Our Ref: AL/8/18/PL

Erection of 2 No. 2 bedroom dwellings with associated parking & landscaping.

Land between 8 & 10 Barnett Close Eastergate

Thank you for your internet representation made on 19th February 2018 which has been recorded as '**an objection**' with the comments as follows:

location plan &
proposed site plan

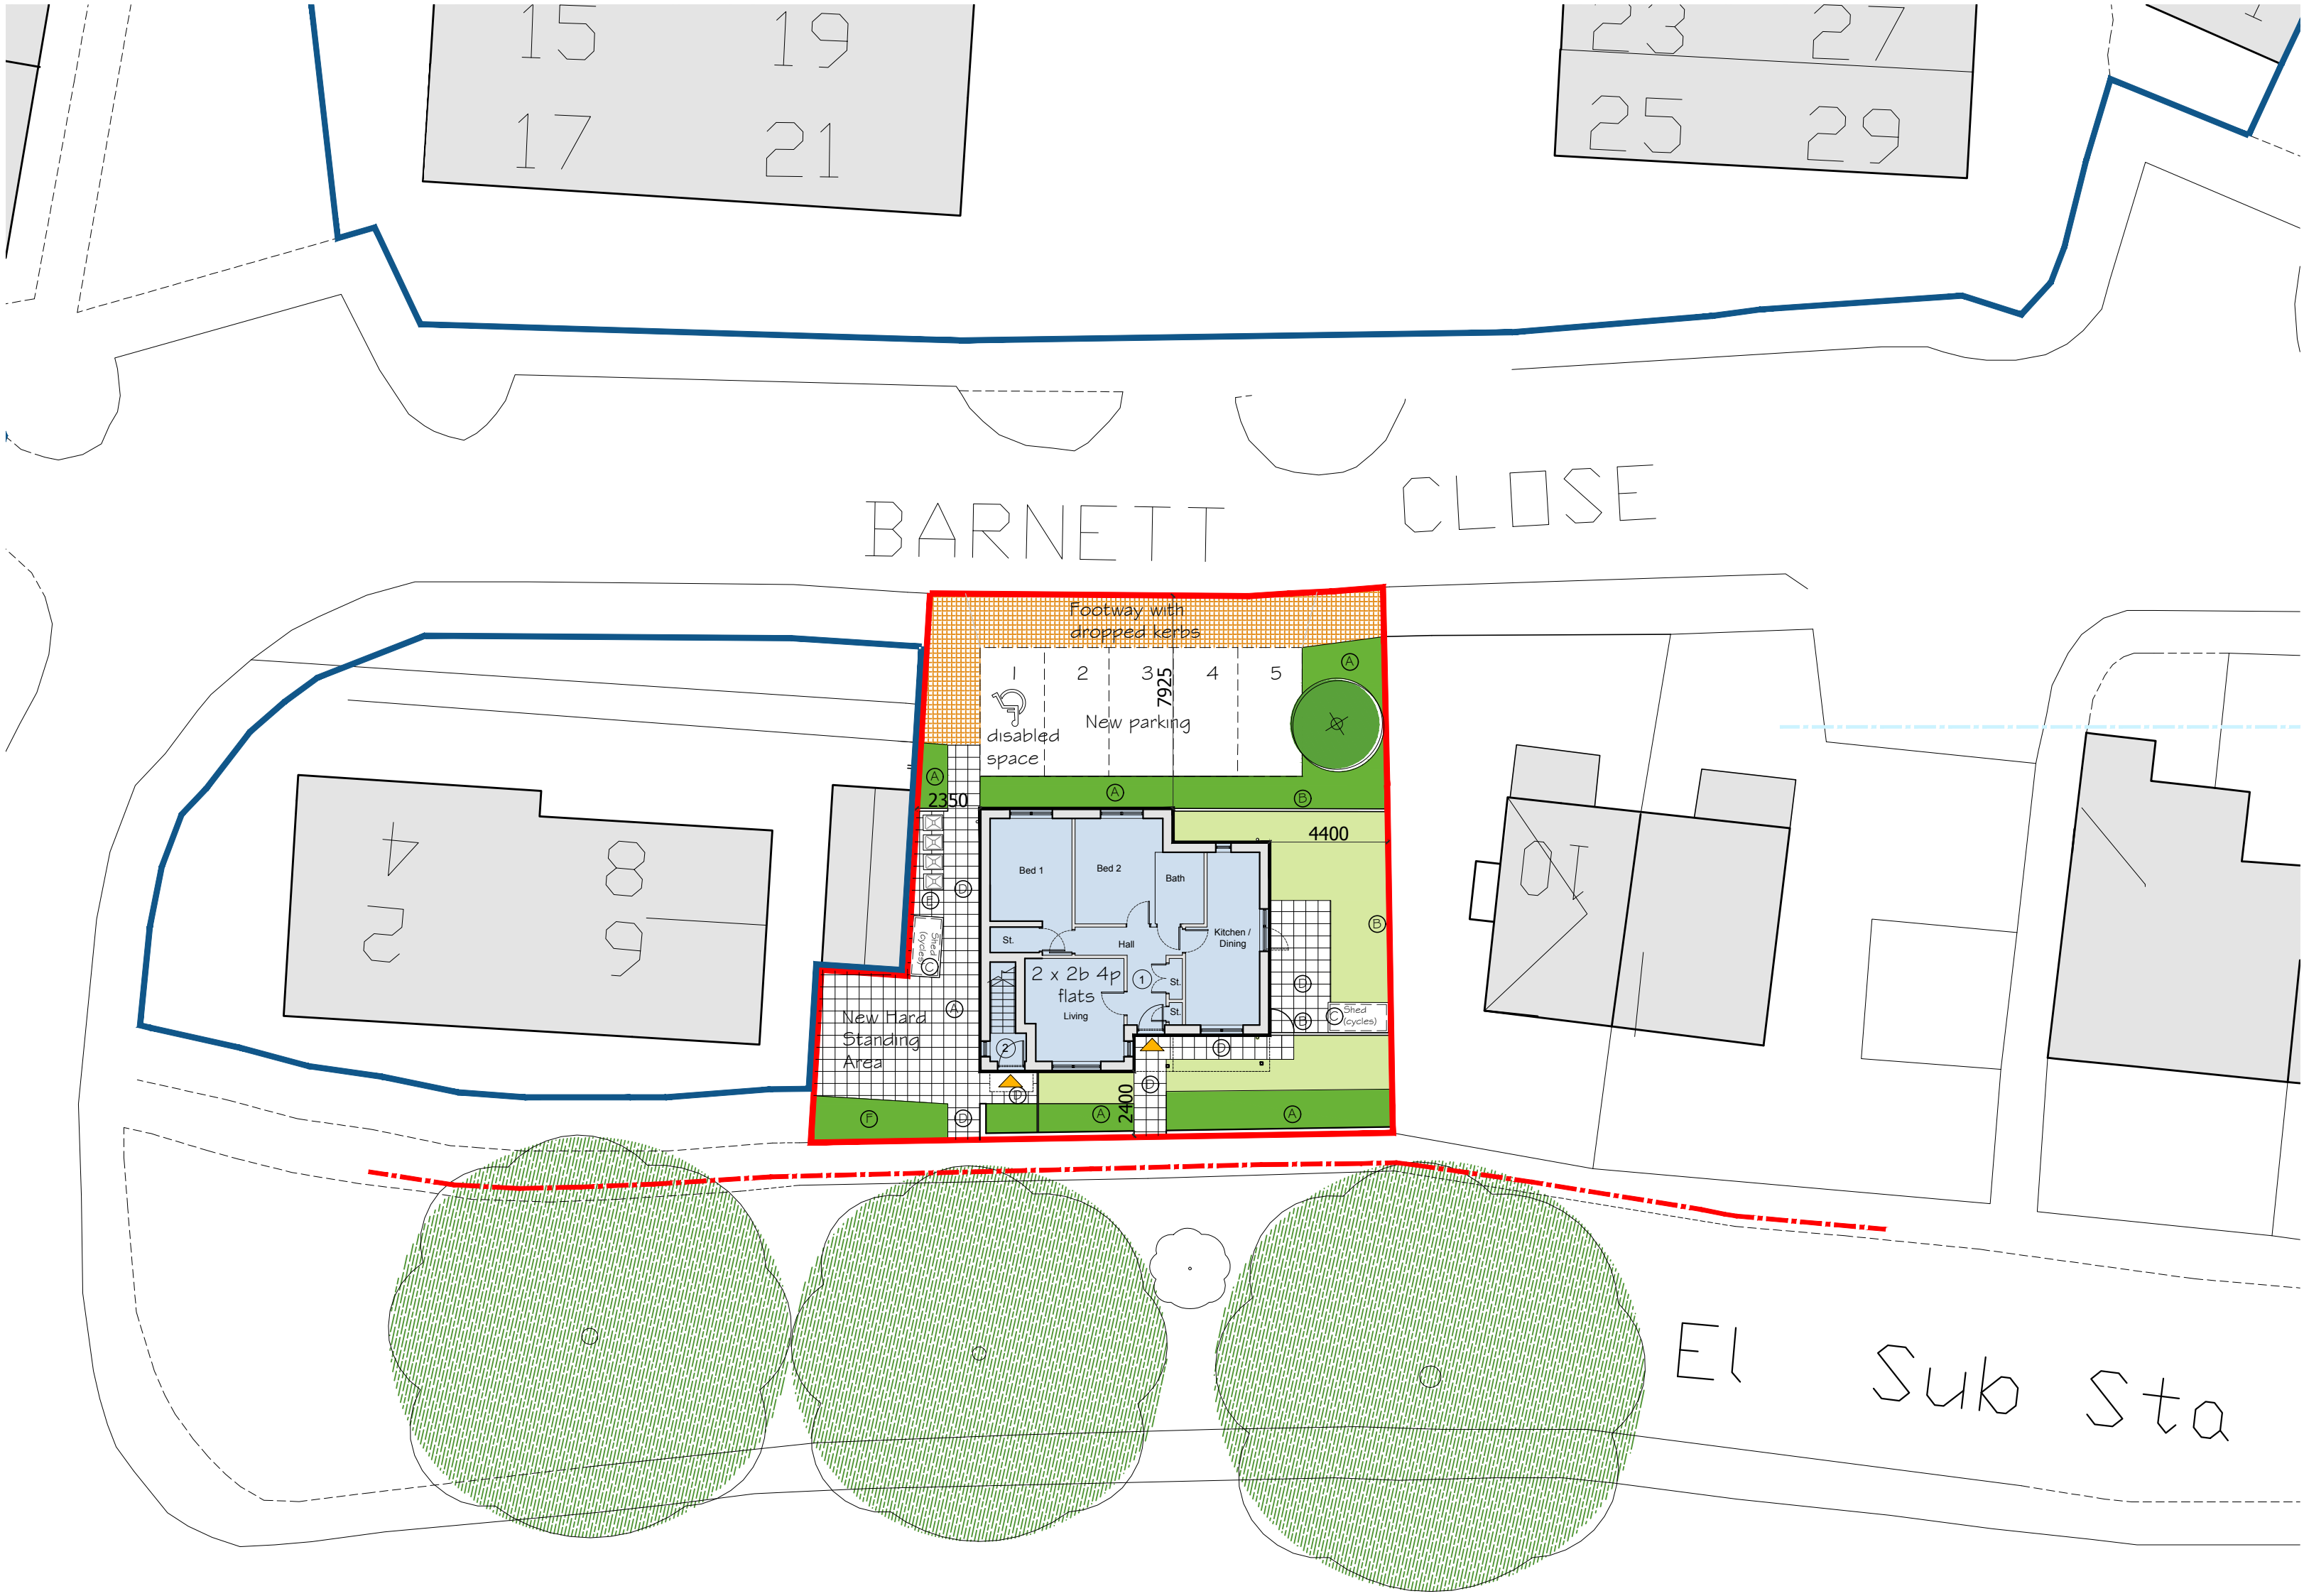
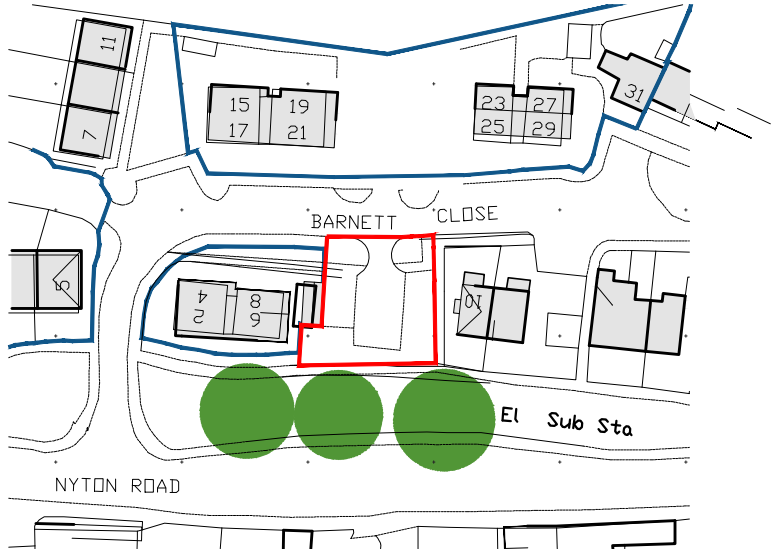
*I would like to object to this application due to the lack of parking, the road is already full and the grass outside being ruined. I am also concerned about losing the washing lines and car park. I feel there is no room and have great safety concerns about this application .
thank you*
